**WEST SUSSEX COUNTY COUNCIL
STRATEGIC PLANNING CONSULTATION**

Arden Guest House, Queens Lane, Arundel, West Sussex

Description of Works: Change of use and extension to create 3no. self
contained apartments and 1no. maisonette. This
application affects the character and appearance of
Arundel Conservation Area

Job Title	Arden Guest House	
Client	Mr & Mrs Meathrel	
Drawing Name	Proposed Ground Floor Plan	
Drawing Status	Planning	
Drawn by	DF	Date Dec 13
Checked by		Date
Drawing Scale	1:50 at A2	
Drawing No	Status	Revision
13519/ 05

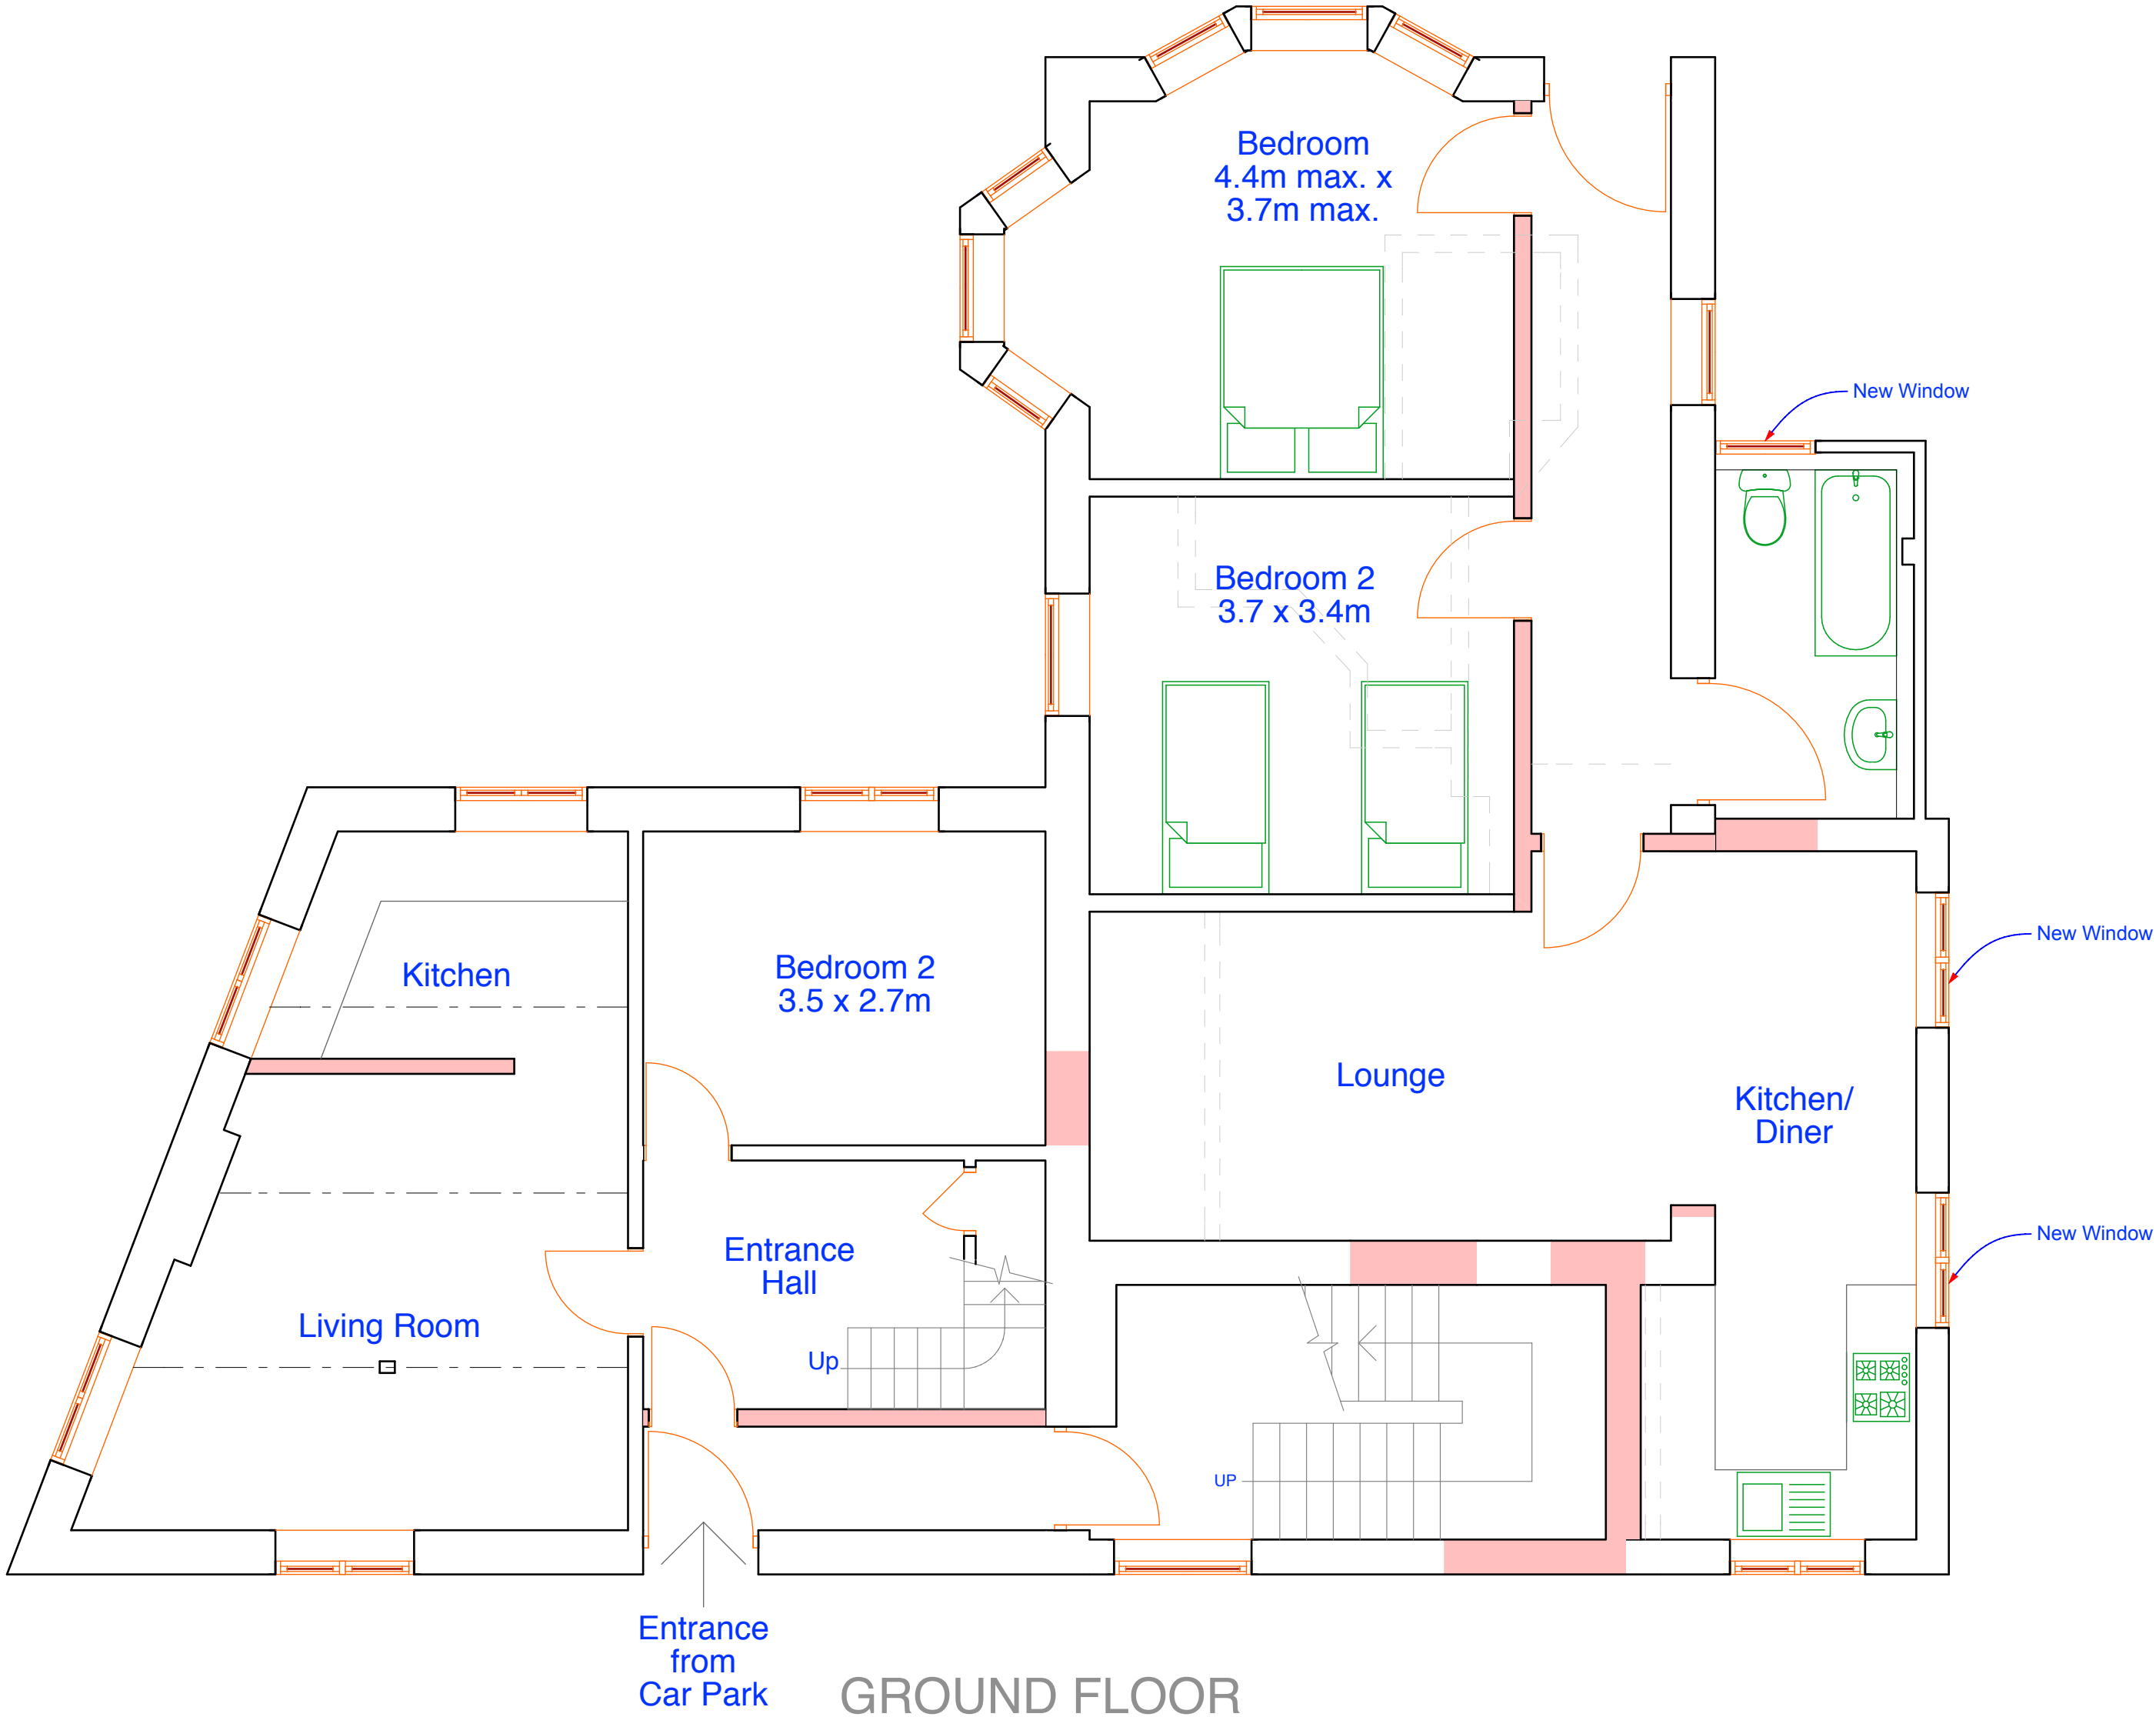
To provide this level of parking the applicant proposes to remove a small section of wall forming the southern boundary abutting Queens Lane, this will provide the visitor space. As illustrated on site plan 13519/09, a vehicle parked in this space will not have the ability to turn on site and will be afforded zero visibility to the west when manoeuvring onto Queens Lane. The applicant has not demonstrated how the space will be accessed; safe manoeuvring in and out of the space could be restricted by vehicles parked on the opposing side of Queens Road. Manual for Streets does advise that 6.0 metres is required to access a bay parking space. There may also be an issue with the level of forward visibility a vehicle approaching west from Fitzalan Road is afforded to a vehicle manoeuvring to park in this space.

A portion of walling will also be removed at the junction of Queens Lane and Fitzalan Road to provide a parking space for Flat 2. The applicant has not demonstrated that this space will be provided with an appropriate level of vehicle visibility.

While WSCC would not wish to object to the principle of the development I would be concerned that the newly created car parking spaces and layout would add to the hazards of the highway users. I would therefore advise that the applicant modify the parking layout accordingly to overcome the concerns raised above. A more practical solution may be to provide one space per flat within the existing hard standing area and consider the application on the basis that visitor parking be provided on street or within the existing pay and display parking provisions within the vicinity.
